**KIRKLEES METROPOLITAN COUNCIL
INVESTMENT & REGENERATION SERVICE**

**DELEGATED DECISION FOR DISCHARGE OF CONDITION A.4 -
NOTIFICATION OF A PROPOSED ENLARGEMENT TO DWELLINGHOUSE**

Reference no.	2020/HH/93242/W
Site Address	49, Birkby Lodge Road, Birkby, Huddersfield, HD2 2BE
Description	The proposal is for erection of single storey extension. The extension projects 6m beyond the rear wall of the original dwellinghouse. The maximum height of the extension is 3.95m, the height of the eaves of the extension is 2.95m
Recommending Officer	Lucy Taylor

PROPOSED GF floor

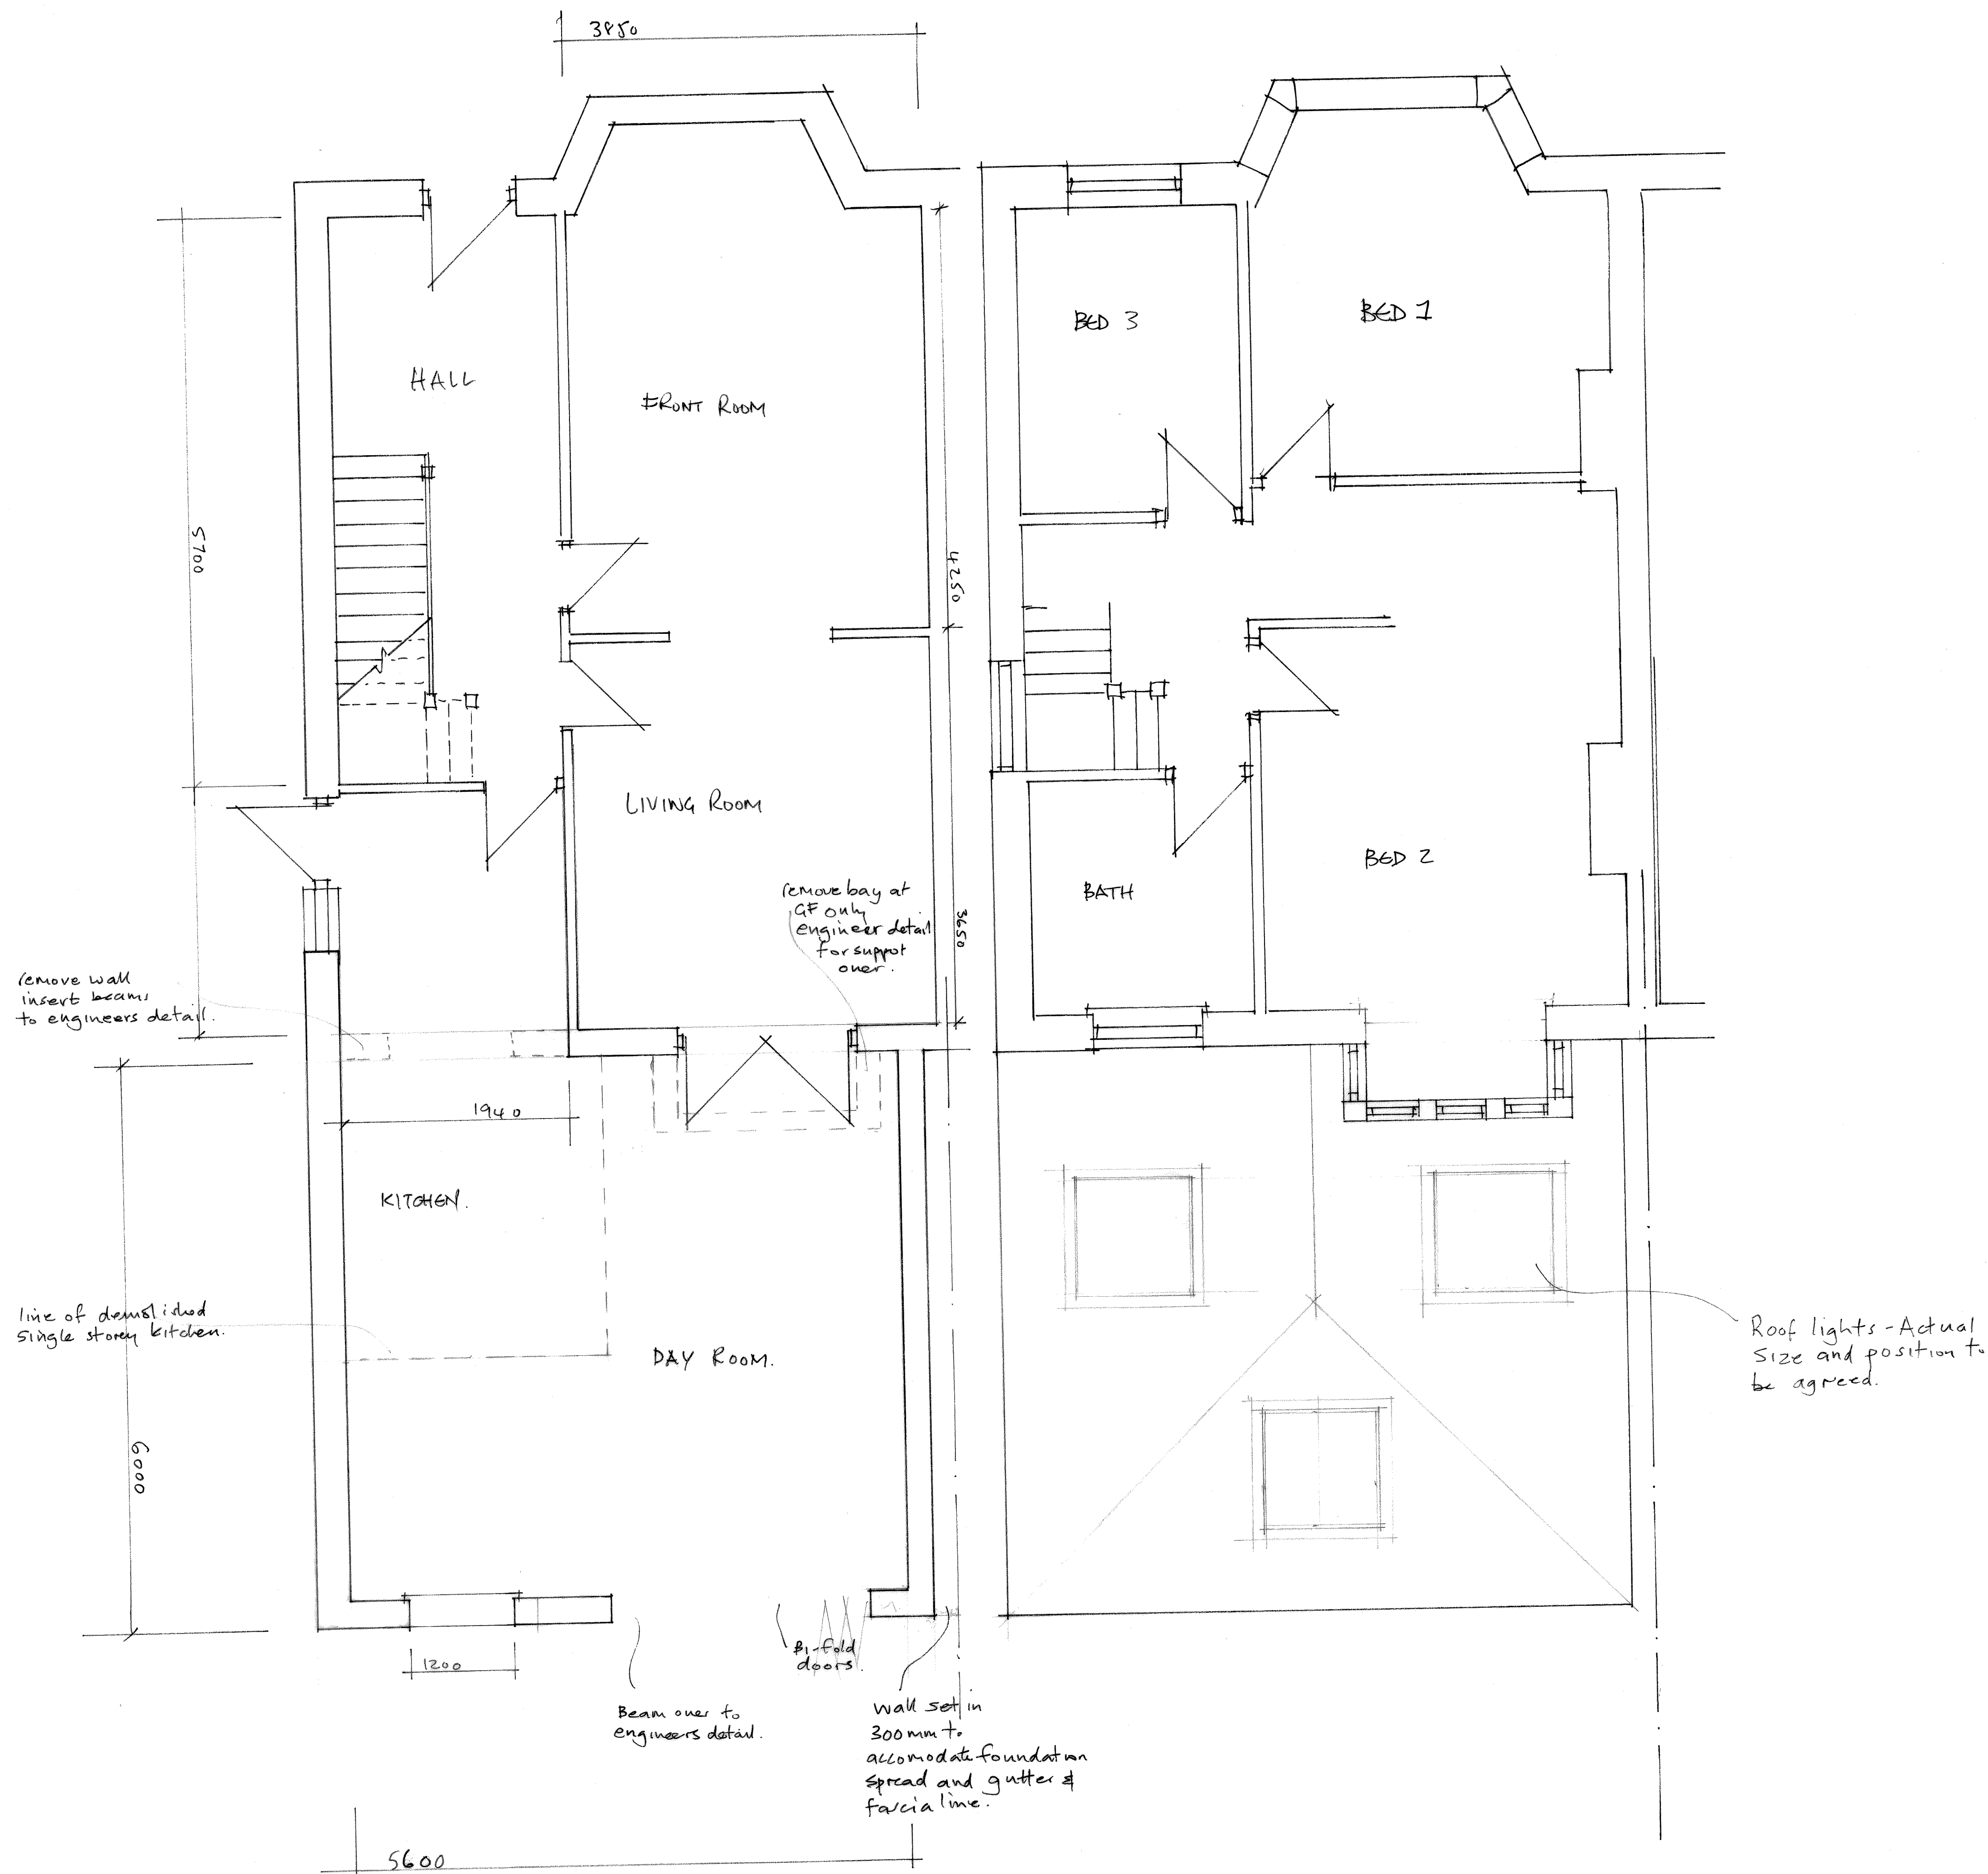
Historical imagery held by the Council shows the existing rearward projection to be an original part of the dwellinghouse. As such, the side wall of the projection would be considered an original side wall and the proposed development extends beyond this side wall. As a result of this the proposal is more than half the width of the original dwellinghouse and therefore is contrary to paragraph (j) of Class A, Part 1 of Schedule 2 of the Town and Country Planning (General Permitted Development)(England) Order 2015(as amended).

Consequently and while you have not been notified of prior approval in accordance with condition A.4 of Class A, the development cannot be considered to benefit from a general planning permission under the General Permitted Development Order and therefore requires full planning permission upon application to the Local Planning Authority.

Advise that planning permission is required.
